Subject: Suncadia Phase 2 Div 5 (LPF-19-00006) Final Long Plat – Staff Review, Request for Additional Information,

Kittitas County Community Development Services (CDS) received your Palomino Fields Division 5 (LPF-19-00004) Final Long Plat submittal on April 12, 2019. Kittitas County staff has completed an initial review of your final plat submittal. As provided below, staff has the following comments, requirements, and/or revisions for your application that need to be addressed prior to final approval and signature of the final plat mylars:

LP-19-00001
LPF-19-00006

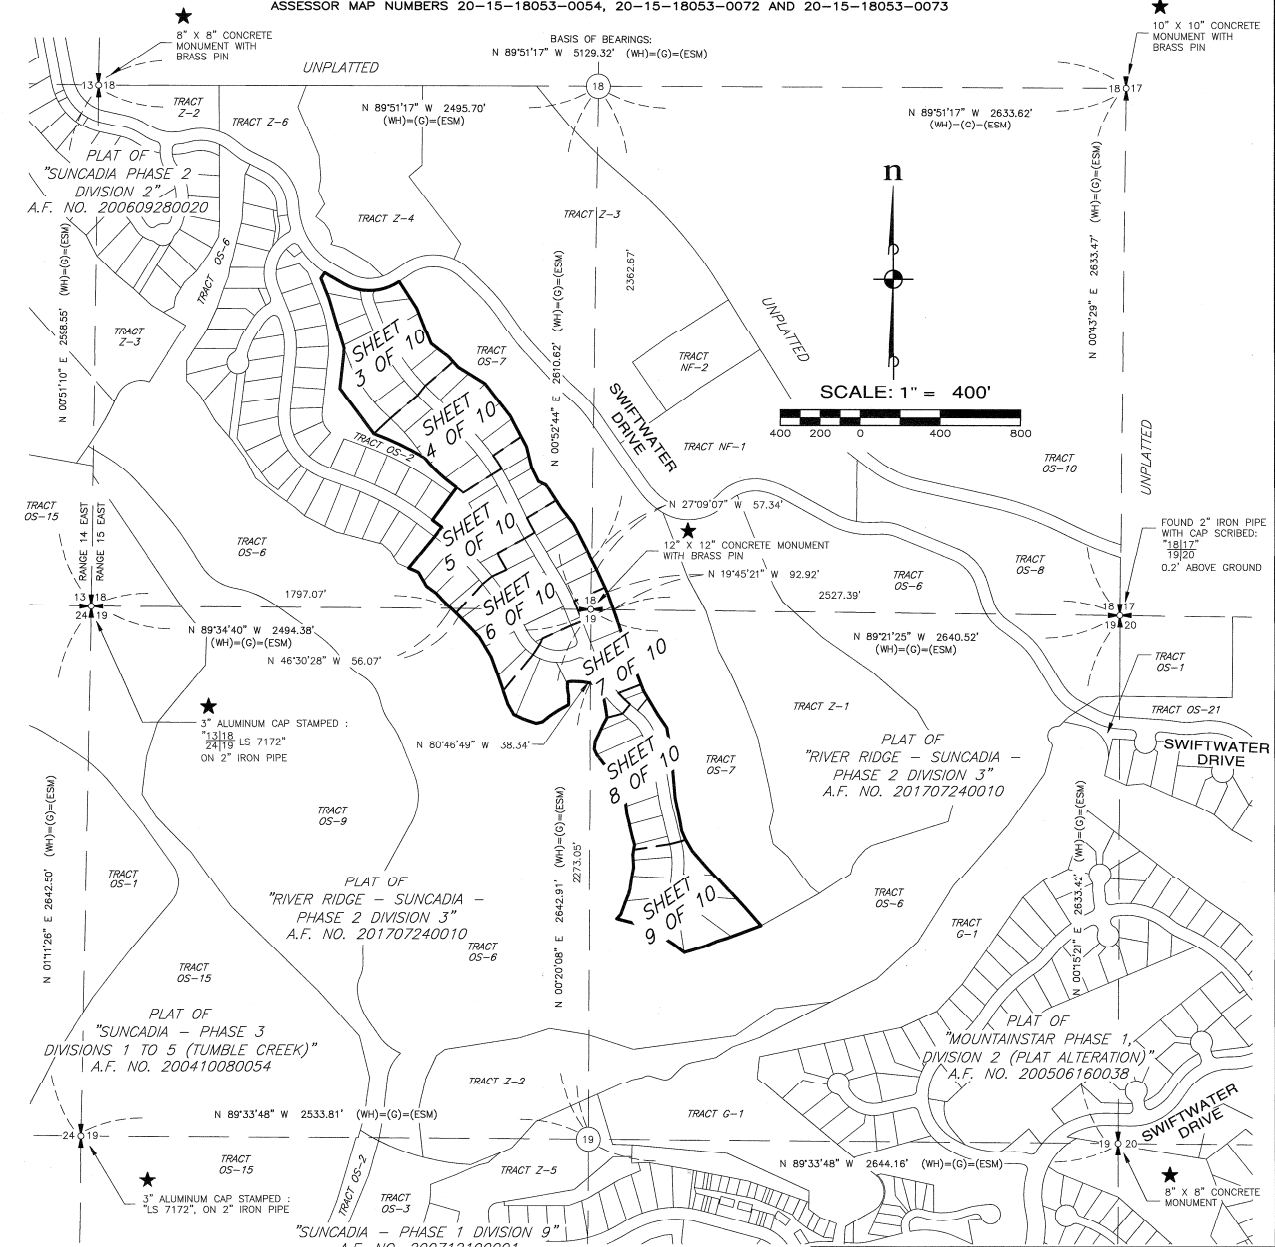
- The file numbers, "LPF-19-00006" and "LP-19-00001" should be represented on the face of the plat.
